East Pye Solar
Statement of Common Ground:
Norfolk County Council

Revision 1
October 2026

Planning Inspectorate Reference: EN0110014
Document Reference: EN0110014/9.4
Rule 8(1)(e) Infrastructure Planning (Examination Procedure) Rules 2010

- ▭ Visibility of Existing
- ▭ Increased Visibility due to Proposed

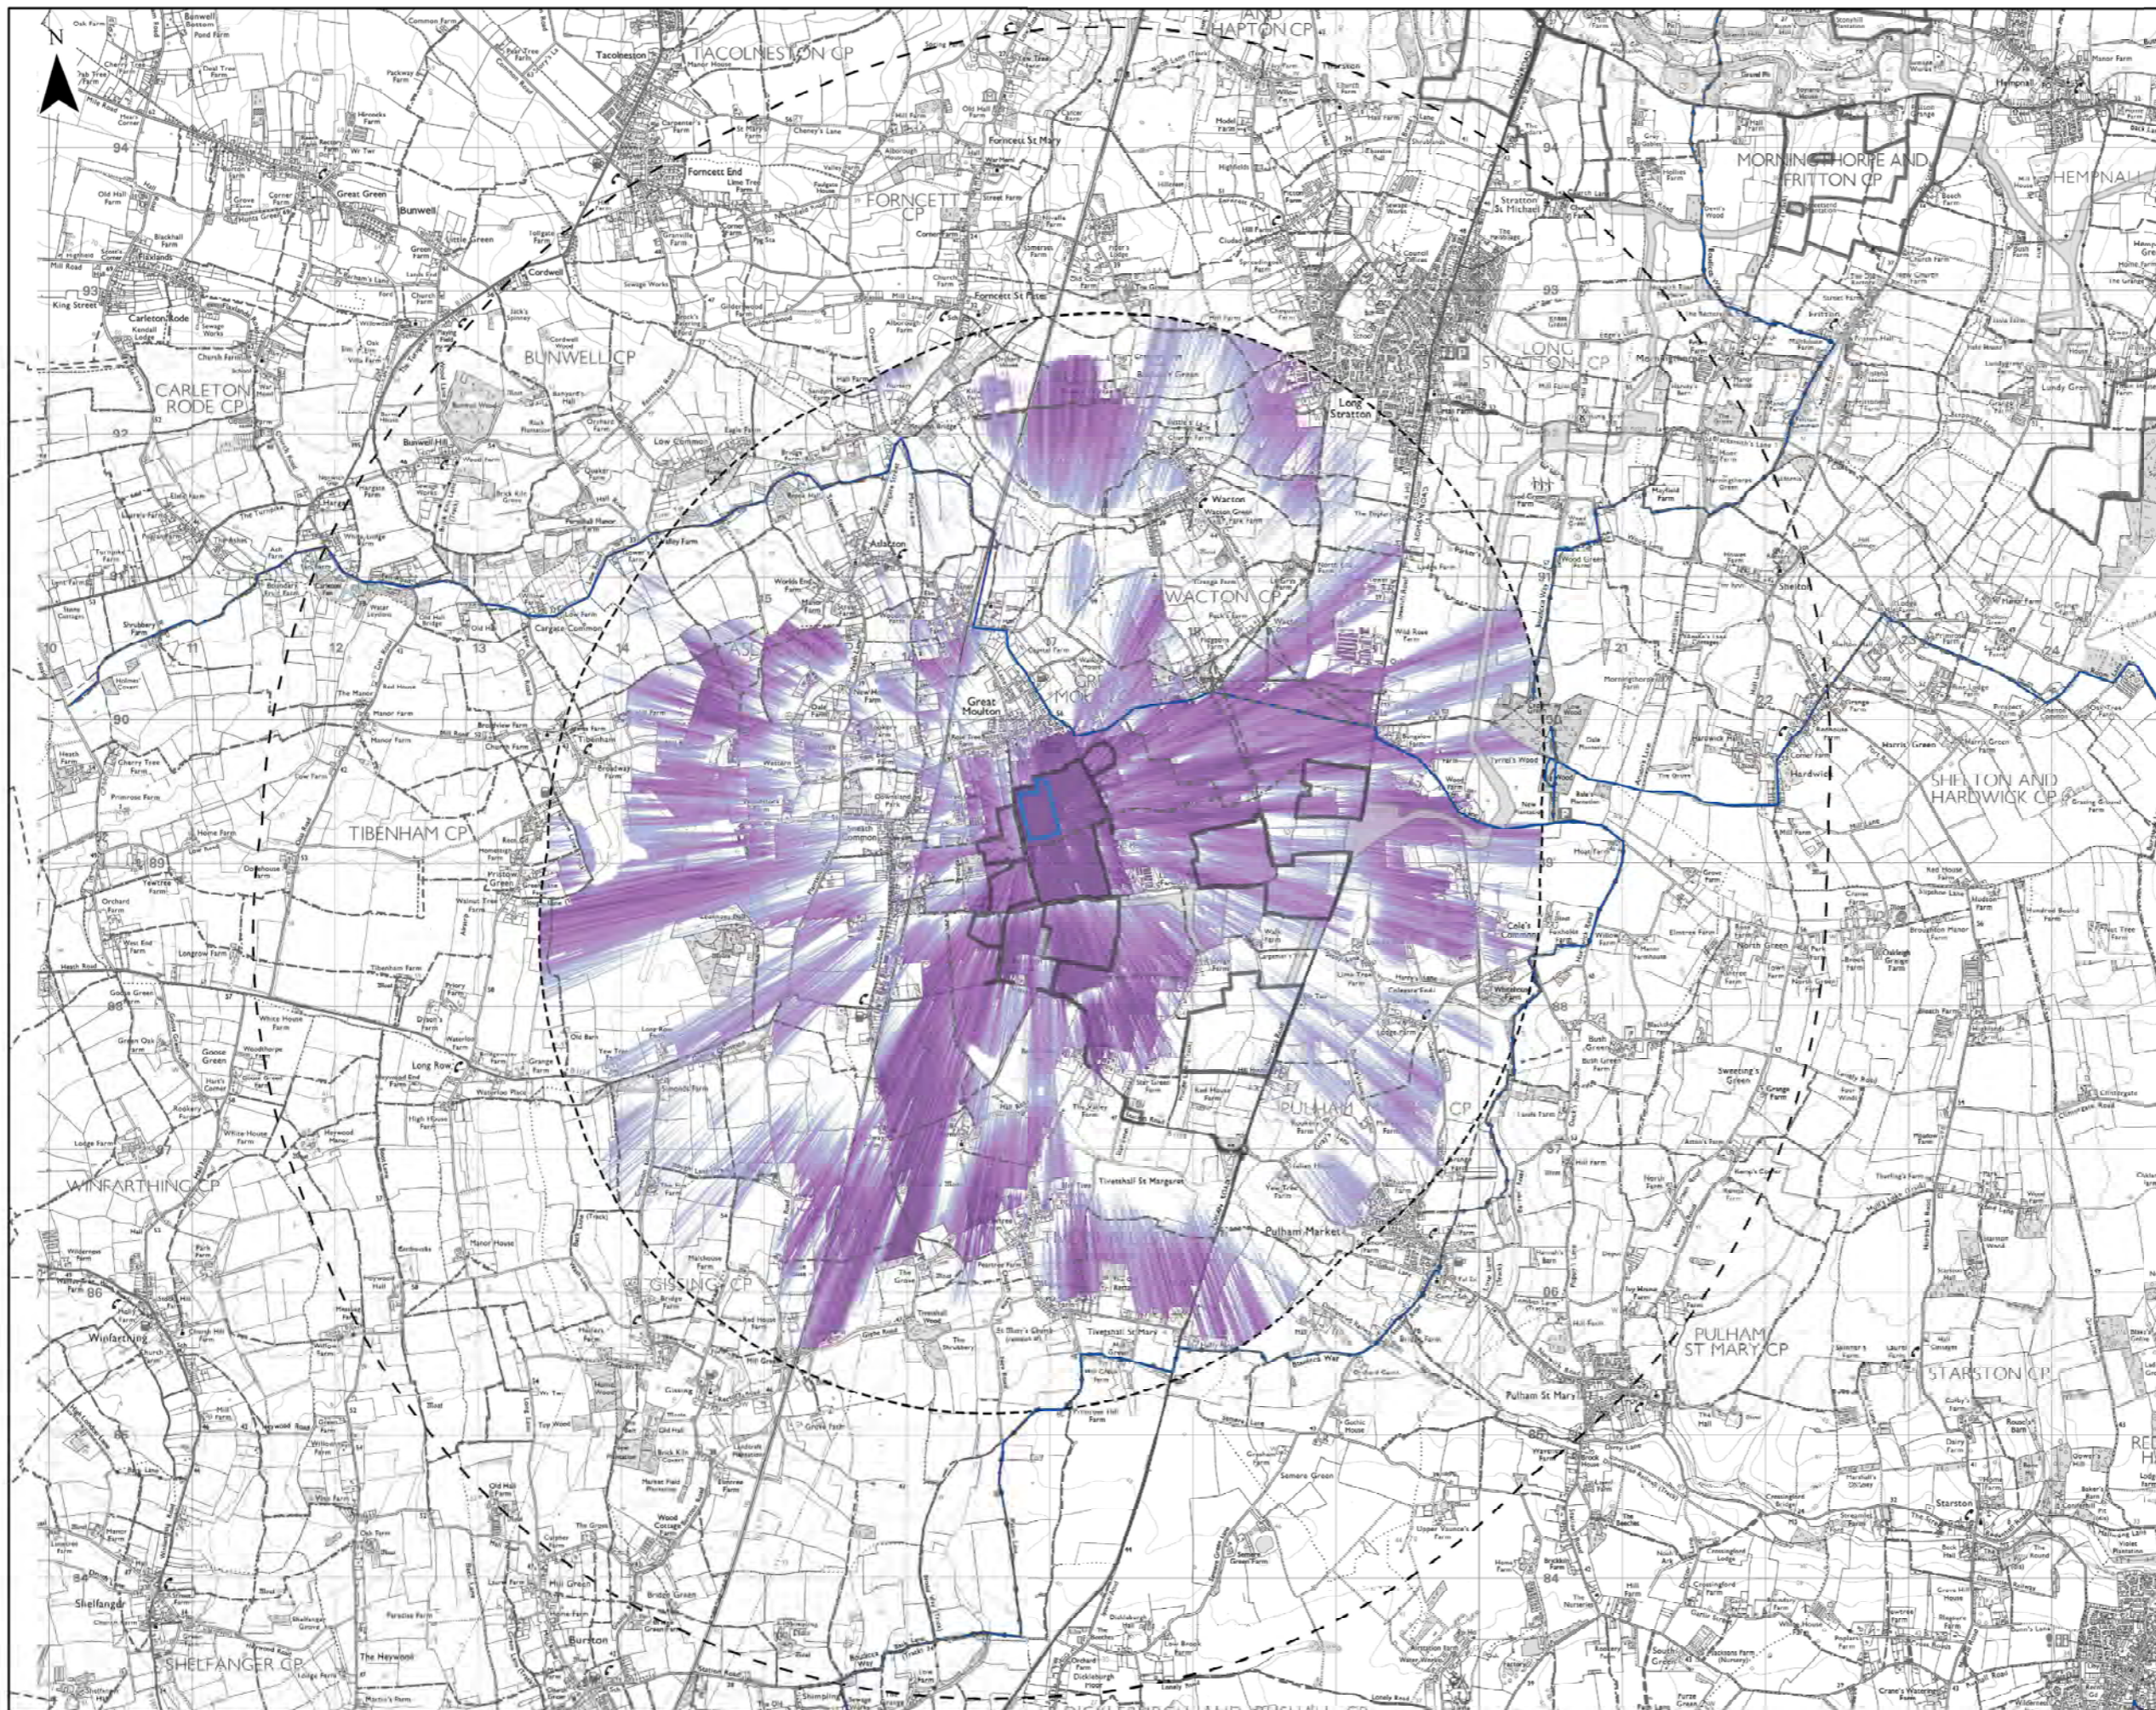
NCC LV – 5	Scope Landscape Character Assessments	ES Volume 1, Chapter 7 - Landscape and Visual [APP-043] ES Volume 3, Appendix 7.2 – Landscape Baseline [APP-119] ES Volume 2, Figure 7.2 - Landscape Character Plan [APP-067]	NCC has reviewed ES Chapter 7 [APP-043] alongside the supporting appendices. The LVIA follows industry standard guidance, including GLVIA3 (Guidelines for Landscape and Visual Impact Assessment) and relevant technical notes.	The published landscape character assessments that are relied upon at the national, regional, and local level and set out within ES Volume 1, Chapter 7 - Landscape and Visual [APP-043] and ES Volume 3, Appendix 7.2 - Landscape Baseline [APP-119] and ES Volume 2, Figure 7.2 - Landscape Character Plan [APP-067] are considered acceptable to inform the assessment baseline conditions.	Under Discussion
NCC LV – 6	Scheme design Concerns about new overhead lines/pylons as part of grid connection – suggest that grid connection cabling undergrounded and no new pylons.	ES Volume 1, Chapter 4 - The Scheme [APP-040] ES Volume 2, Figure 7.5.10 - Site 1 Zone of Theoretical Visibility [APP-079] ES Volume 2, Appendix 7.7 - Visual Assessment Tables [APP-147]	NCC is concerned the new overhead lines and pylons will have wider visual impact and will have disruption during construction. NCC suggested used of underground cables where possible to connect to the existing 400kV line.	The Applicant has sought to minimise the effect and extent for new overhead cables with siting of the National Grid Substation in close proximity to the existing 400kV line. Grid connection infrastructure will nevertheless be required between the National Grid Substation and the existing 400 kV overhead line (Norwich Main – Bramford). The final design of the substation is ultimately at National Grid's discretion. As such, the Applicant has assessed a reasonable worse case scenario in which the connection from the National Grid substation and the NETS was assessed as using overhead lines, as opposed to underground cables. The Scheme proposes to divert the existing 400 kV overhead line into a newly constructed National Grid Substation. ES Volume 1, Chapter 4 - The Scheme [APP-040] describes the proposed works in relation to the grid connection and proposed pylons.	Under Discussion

Reference	Matter Topic	Document Reference of Matters	Consultee Position	Applicant's Position	Status
				A comparative ZTV is produced as part of ES Volume 2, Figure 7.5.10 - Site 1 Zone of Theoretical Visibility [AS-007] . The Applicant considers the visibility of the additional pylon is similar to the baseline. Where the proposed additional pylon has the potential to influence visual amenity, this has been assessed within ES Volume 2, Appendix 7.7 - Visual Assessment Tables [APP-147] .	
NCC LV – 7	Scheme design Favoured national grid Substation option further away from Great Moulton	Site Selection Assessment [APP-215]	The consultee favoured the option with the National Grid Substation further away from Great Moulton.	The Site Selection Assessment [APP-215] explains the rationale for why the National Grid Substation has been located at Site 1b.	Not Agreed
NCC LV – 8	Scheme design Concern about the upgrade of the 132 kV substation south of Great Moulton to 400kV which will have a greater visual impact.	ES Volume 1, Chapter 7 - Landscape and Visual [APP-043]	The consultee is concerned about the upgrade of the 132 kV substation south of Great Moulton to 400kV which will have a greater visual impact.	The visual effects of the 400kV Project Sub-Station adjacent to the proposed National Grid substation south of Great Moulton has been assessed within ES Volume 1, Chapter 7 - Landscape and Visual [APP-043]. As set out in the Site Selection Assessment [APP-215], the chosen location for the National Grid Substation avoids major designated areas of ecological or cultural importance, with only limited priority habitats and no heritage assets, County Wildlife Sites or Ancient Woodland present. The National Grid Substation and overhead lines would therefore avoid areas of high amenity, cultural, and scientific value in line with the Holford / Horlock Rules and NPS EN-5. As part of the design evolution, the National Grid Substation was also reorientated north south to enable greater opportunities of screening from existing vegetation to the north to reduce the visibility from Great Moulton and provide a greater offset from Narrowgate Way PRow demonstrating that landscape and visual effects have been minimised through iterative design. NPS EN-1 states at para 5.10.5 that ‘<i>Virtually all nationally significant energy infrastructure projects will have adverse effects on the landscape</i>’, and at para 5.10.13 that ‘<i>All proposed energy infrastructure is likely to have visual effects for many receptors around proposed sites</i>’. Due to the scale of the proposed infrastructure in Site 1, the Applicant identifies change to some of the key characteristics and visual amenity of Site 1	Under Discussion
